From: Contact Centre (CRM) <contact@ribblevalley.gov.uk>
Sent: 13 April 2026 14:42
To: Planning
Subject: Planning Application Comments - 3/2026/0247 FS-Case-826650665

Planning Application Reference No.: 3/2026/0247

Address of Development: Spout Farm, Preston Road, Longridge, PR3 3BE

Spout Farm

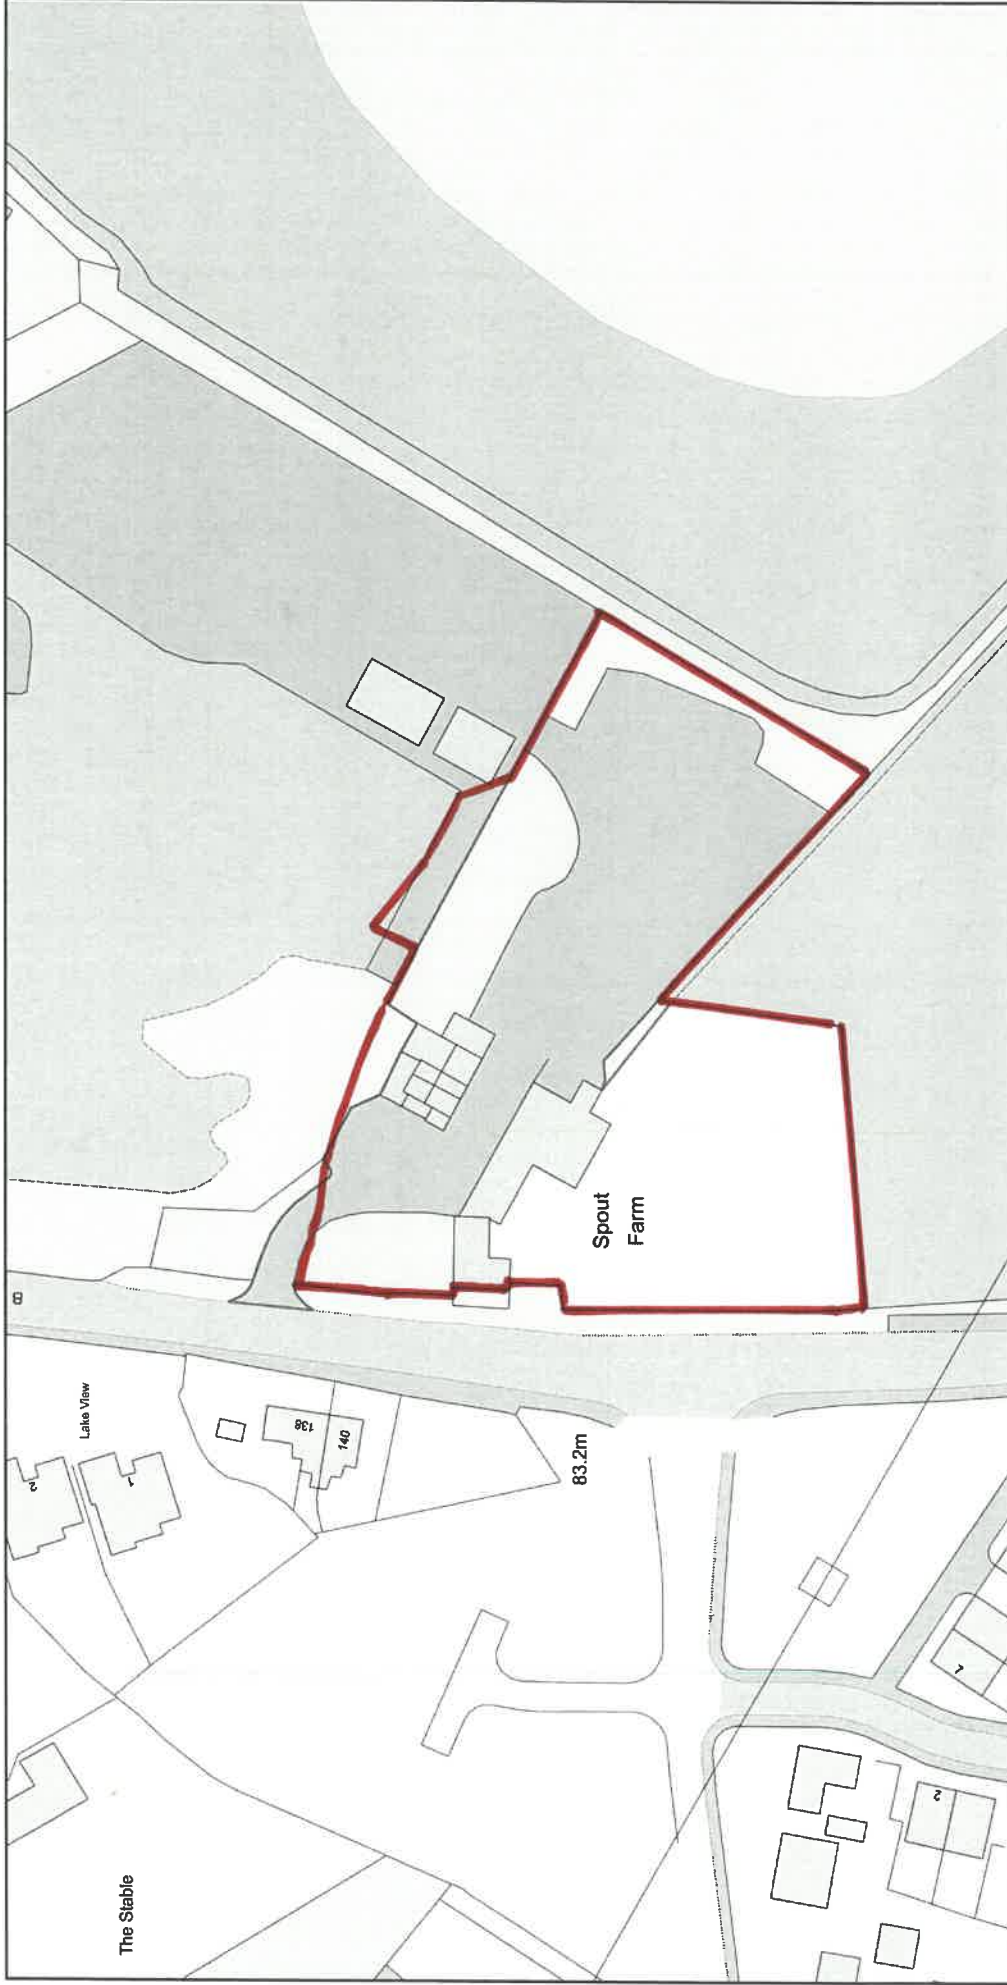
Comments: [REDACTED], Longridge, and I formally object to the above Permission in Principle application. My objection is based on a fundamental and material error in the application documents: the submitted location plan incorrectly claims land that does not belong to the applicant, Mr Denis Lambert, and which is registered under Land Registry title LAN242913 as forming part of The Sandpipers development.

The location plan submitted with application 3/2026/0247 includes land that is not in the ownership of the applicant. Specifically, the red line boundary encroaches upon land that forms part of The Sandpipers residential development which is recorded under Land Registry title LAN242913. This title was provided to purchasers of properties on this estate at the time of conveyancing and clearly defines the boundary of the Sandpipers land.

The Land Registry title directly contradicts the site boundary as drawn by the applicant. This is not a minor discrepancy — it is a material misrepresentation of the ownership position. The Local Planning Authority should verify the applicant's legal ownership of all land within the red line boundary before this application is determined. A Permission in Principle cannot lawfully be granted over land that the applicant does not own.

The planning statement (Section 5.3) proposes to utilise the existing vehicular access to the site via Preston Road. However, the access arrangement identified in the submitted plans includes a strip of road directly in front of plots 32, 33, and 34 of The Sandpipers estate. According to the deed plans and Land Registry title LAN242913 provided to purchasers on this estate, this strip of road is shared access and is to be managed by the Sandpipers (Longridge) Management Company — it is not the property of Mr Lambert.

The submitted location plan also appears to include within the site boundary areas of public open space and common land that form part of The Sandpipers estate. These areas are not in the ownership of the applicant. Including them within the red line boundary of this application without title to those areas is a material error that renders the application as submitted inaccurate and misleading.

The location plan submitted with application 3/2026/0247 includes land that is not in the ownership of the applicant. Specifically, the red line boundary encroaches upon land that forms part of The Sandpipers residential development and which is recorded under Land Registry title LAN242913. This title was provided to purchasers of properties on this estate at the time of conveyancing and clearly defines the boundary of the Sandpipers land.

The Land Registry title directly contradicts the site boundary as drawn by the applicant. This is not a minor discrepancy — it is a material misrepresentation of the ownership position. The Local Planning Authority should verify the applicant's legal ownership of all land within the red line boundary before this application is determined. A Permission in Principle cannot lawfully be granted over land that the applicant does not own.

The planning statement (Section 5.3) proposes to utilise the existing vehicular access to the site via Preston Road. However, the access arrangement identified in the submitted plans includes a strip of road directly in front of plots 32, 33, and 34 of The Sandpipers estate. According to the deed plans and Land Registry title LAN242913 provided to purchasers on this estate, this strip of road is shared access and is to be managed by the Sandpipers (Longridge) Management Company — it is not the

The submitted location plan also appears to include within the site boundary areas of public open space and common land that form part of The Sandpipers estate. These areas are not in the ownership of the applicant. Including them within the red line boundary of this application without title to those areas is a material error that renders the application as submitted inaccurate and misleading.

There is a material inconsistency between the site boundary identified in the application and the registered title LAN242913 (see attached). Land Registry records indicate the applicant does not own the land in front of Plots 32, 33, and 34, which is designated as shared access for the benefit of The Sandpipers residents. As a resident of the estate, I formally dispute the applicant's right to include this land within their red-line boundary or to utilise it for intensified residential access.

The red line site location drawing includes areas of land on the boundaries which is disputed between the Mr Lambert and development owners Create Homes. I also detailed my concerns to the Land Registry (ref. Complaint reference CMP251102-010376) dated 02Nov25.

There is a clear mismatch between the red-line boundary shown in the application and the registered title LAN242913 (see attached evidence). The applicant does not own the land fronting Plots 32, 33 and 34 – this land is designated as shared access for the benefit of all Sandpipers residents. As someone living on the estate, I formally dispute the applicant's right to include this land in their proposal or to intensify its use for additional housing access.

The reason for highlighting this action is due to the planning map provided by PWA in support of this application is at odds with the planning drawing referenced Revision P06 UG-487-LAN-HL[1]DRW-02.

Point 3.3.1 - reference to the Sandpipers Development and approval 03/2020/0309 which contradicts the location plan submitted on this application. The boundary lines encroach onto the Sandpipers development Land Registry title number LAN242913

- (a) Require the applicant to provide documentary proof of legal ownership of all land within the red line boundary;
- (b) Cross-reference the submitted location plan against Land Registry title LAN242913 and the approved plans for application 3/2020/0309;
- (c) Refuse to determine this application until and unless the boundary error is resolved; and
- (d) Give full weight to the factual inaccuracies in the planning statement when assessing this application.

- (a) Require the applicant to provide documentary proof of legal ownership of all land within the red line boundary;
- (b) Cross-reference the submitted location plan against Land Registry title LAN242913 and the approved plans for application 3/2020/0309;
- (c) Refuse to determine this application until and unless the boundary error is resolved; and
- (d) Give full weight to the factual inaccuracies in the planning statement when assessing this application.
